DRB Application No.: <u>03-01519 (P&F)</u>	Project # <u>1002738</u>
Project Name: <u>EASTERN ADDITION</u>	EPC Application No.:
Agent: <u>Surveys Southwest</u>	Phone No.: <u>998-0303</u>

**CITY OF ALBUQUERQUE
PLANNING DEPARTMENT
Development Review Board
September 24, 2003 Comments**

RE: Lots 1-3, Block M, Eastern Addition/Prelim & Final

Project Name: Eastern Addition, Lots 1-3, Block M

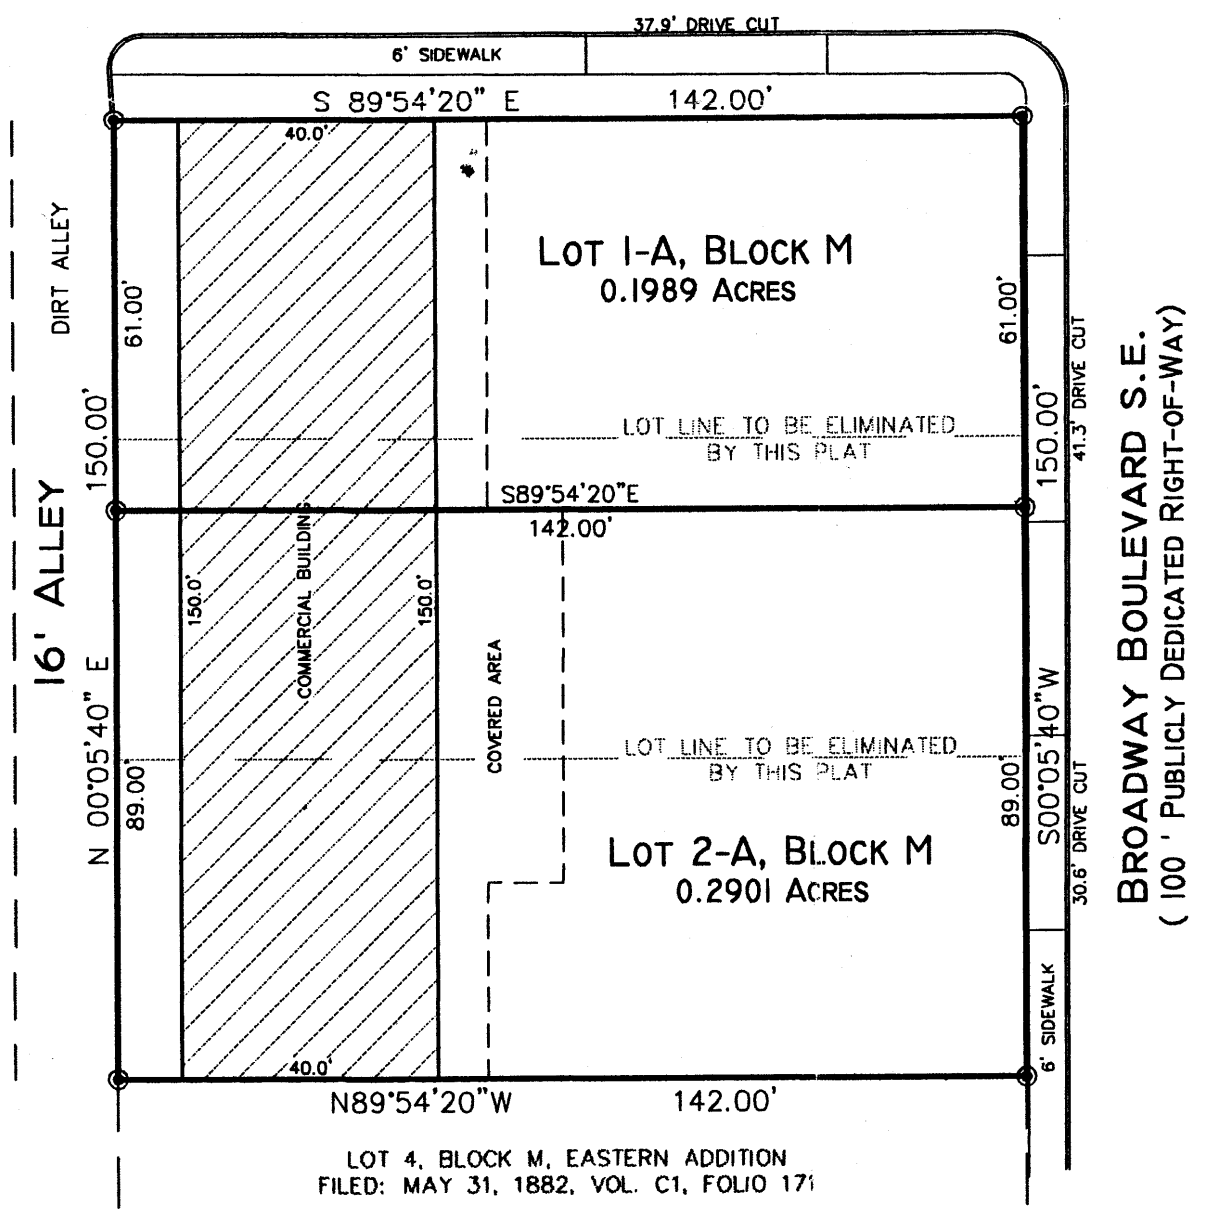
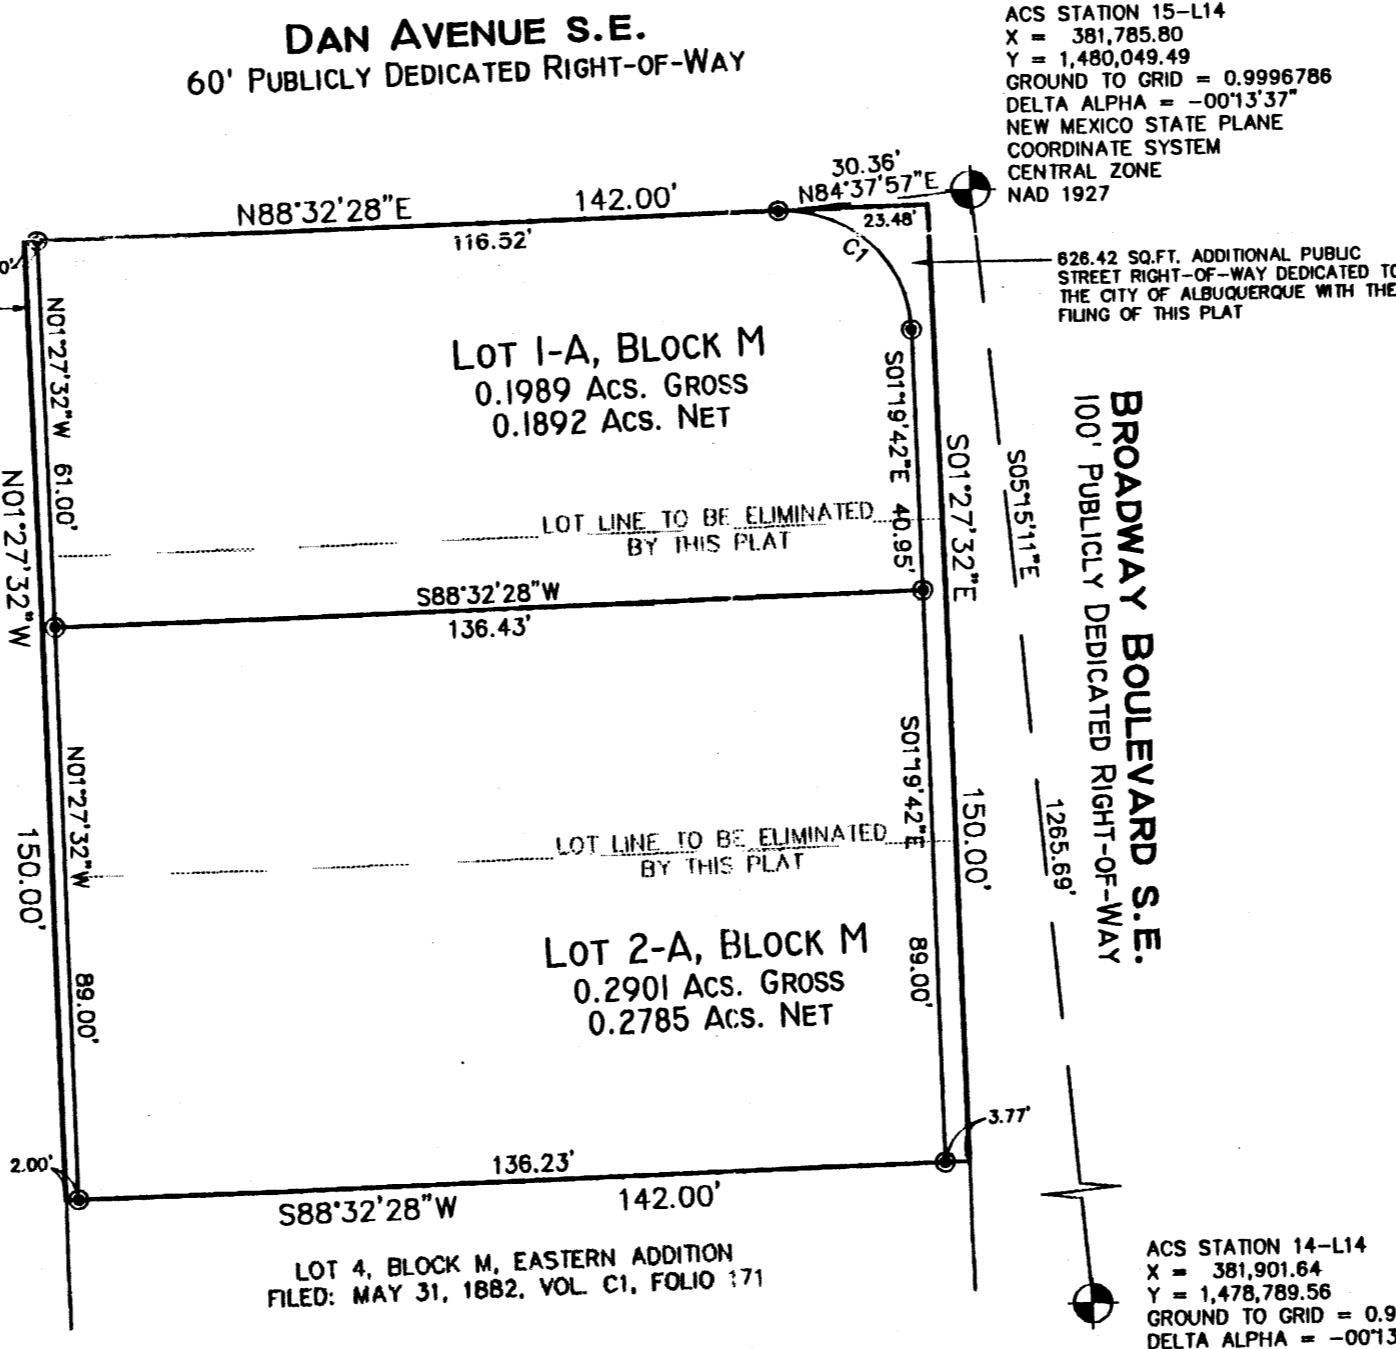
If the existing parking is now shared, there may need to be a joint parking agreement. If there is one premise sign identifying all uses, a joint sign agreement may be needed.

<u>No.</u>	<u>Comment</u>
<input type="checkbox"/>	Alley improvements are needed, additional dedication for alley is likely.
<input type="checkbox"/>	Need to dedicate 10 ft. from the face of Broadway as right-of-way along with a 20 ft corner radius.

Why is the new lot line going through the middle of what appears to be an existing building?
